## Appendix A- Record and Response to Submissions

Extracts from Government agency and authority submissions and submissions from the general public received in relation to SSD 17\_8351, and a response to each of these matters, has been outlined in the **Table below**.

Shadow cast by existing
and approved buildings

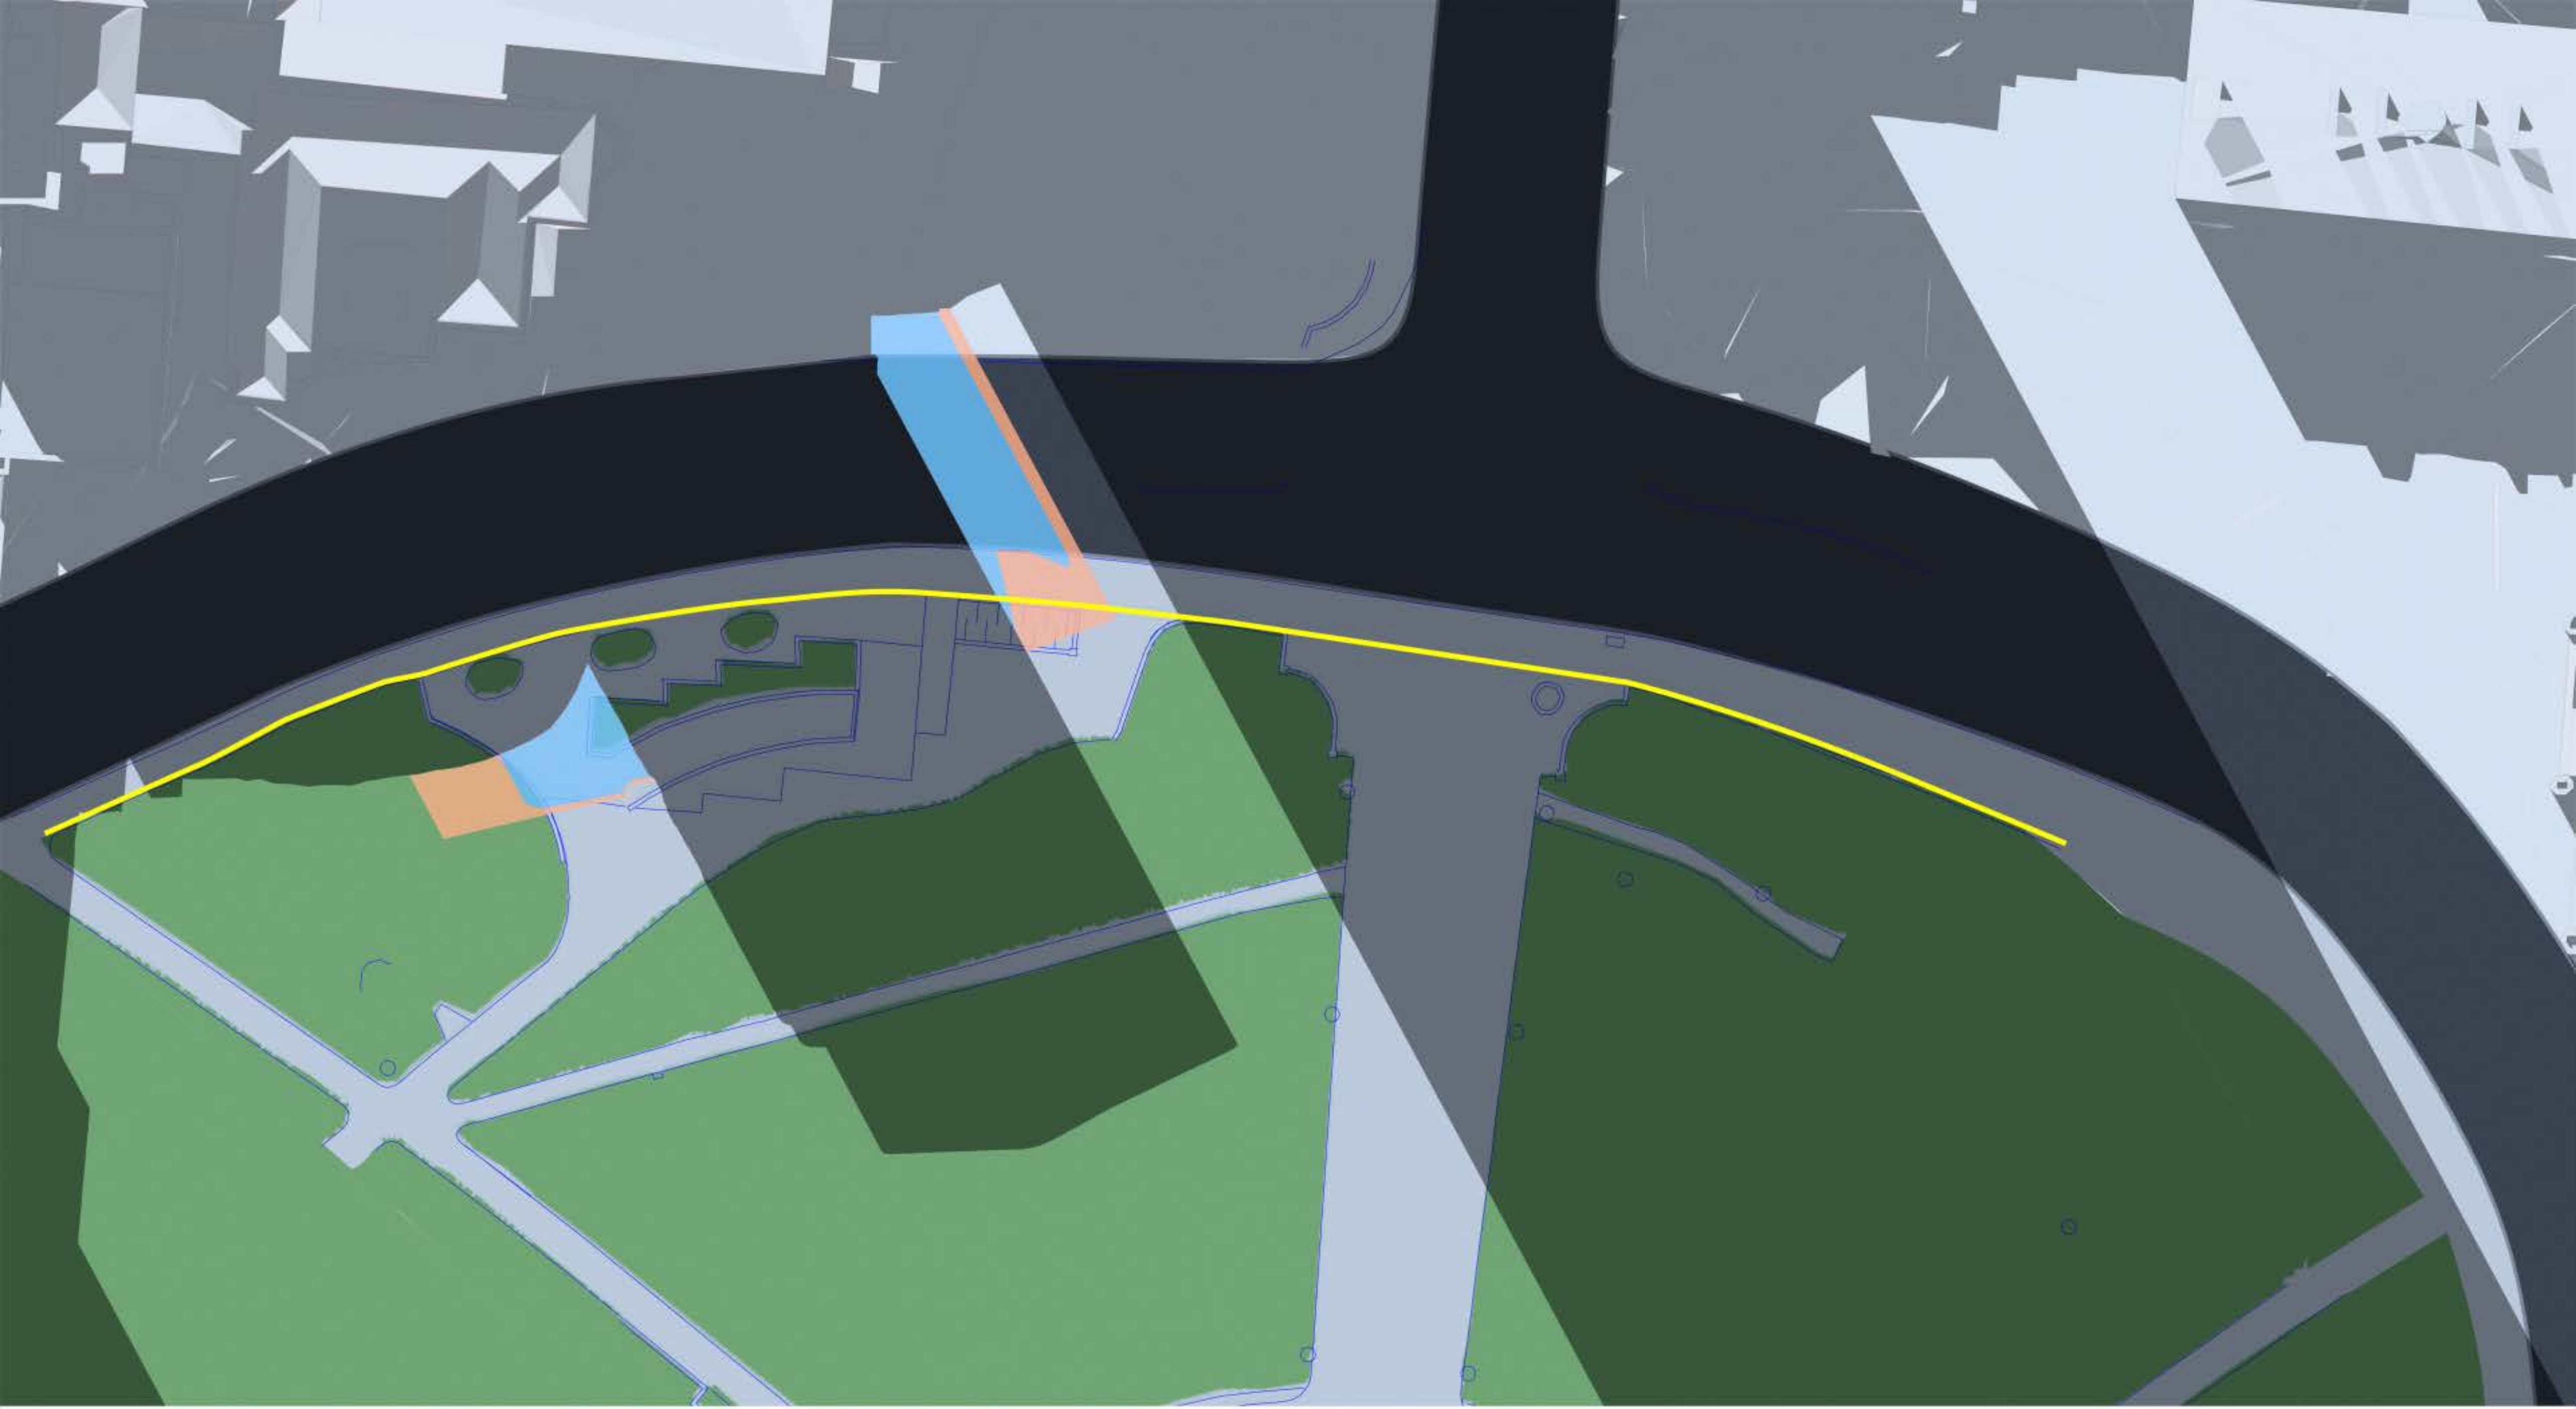
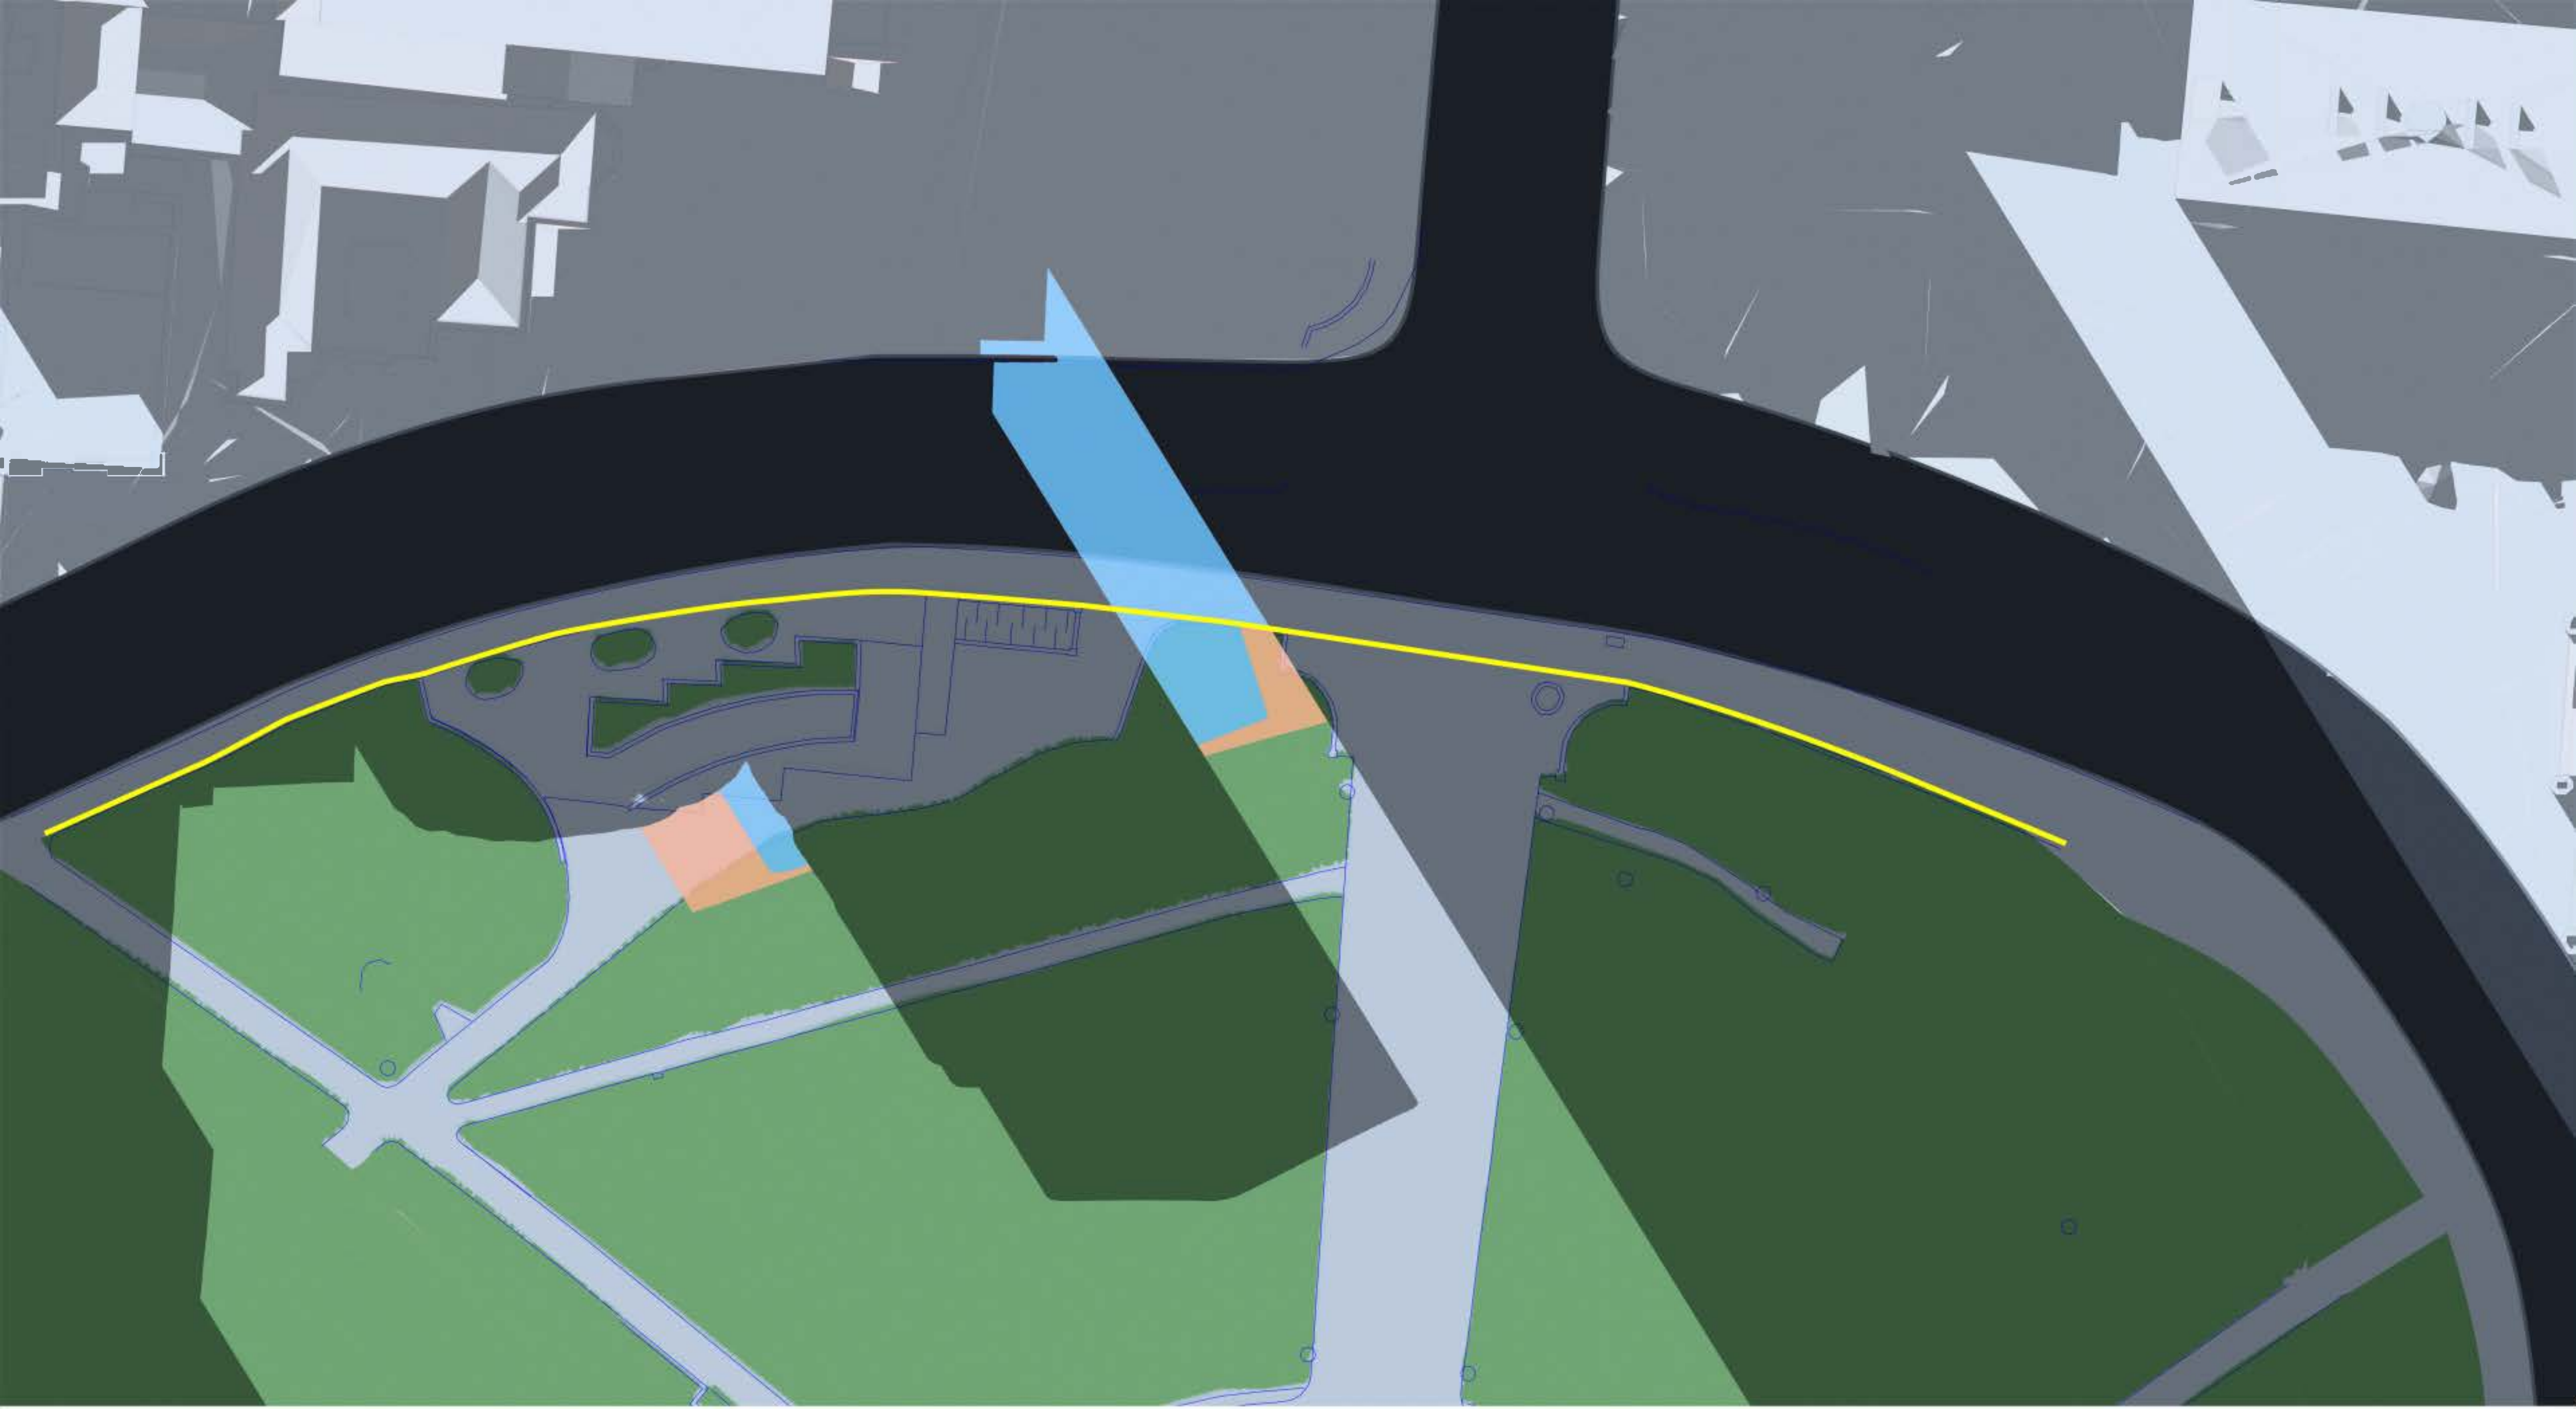
Review the impact of the proposal on solar access to Hyde Park in mid-winter, and how the proposal is consistent with the objectives within the SLEP 2012 to protect the amenity of public places. This should include an analysis of the overshadowing impacts on Hyde Park in comparison to a development which would apply the setbacks of SDCP 2012.	The revised overshadowing analysis at <b>Appendix C</b> confirms the relative impact of the proposed building envelopes when compared to a LEP/DCP compliant scheme. It demonstrates that in addition to the proposed envelopes being consistent with both the existing and potential future Sun Access Planes applying to the Site, these building envelopes will also not generate substantial or long-lasting shadows on Hyde Park consistent with the objectives and requirements of Cl. 6.16 of the Sydney LEP 2012. It is further demonstrated that minor overshadowing generated by the proposed envelopes is comparable to the compliant scheme, and as such are comparable to what would otherwise be expected under the controls as smaller, older buildings are replaced with new buildings designed to the City's height limits. The degree of additional shadow is also consistent with that which results from development in which the City of Sydney Council readily supports and approves (e.g. 148 King Street). Refer to the RTS for further discussion.
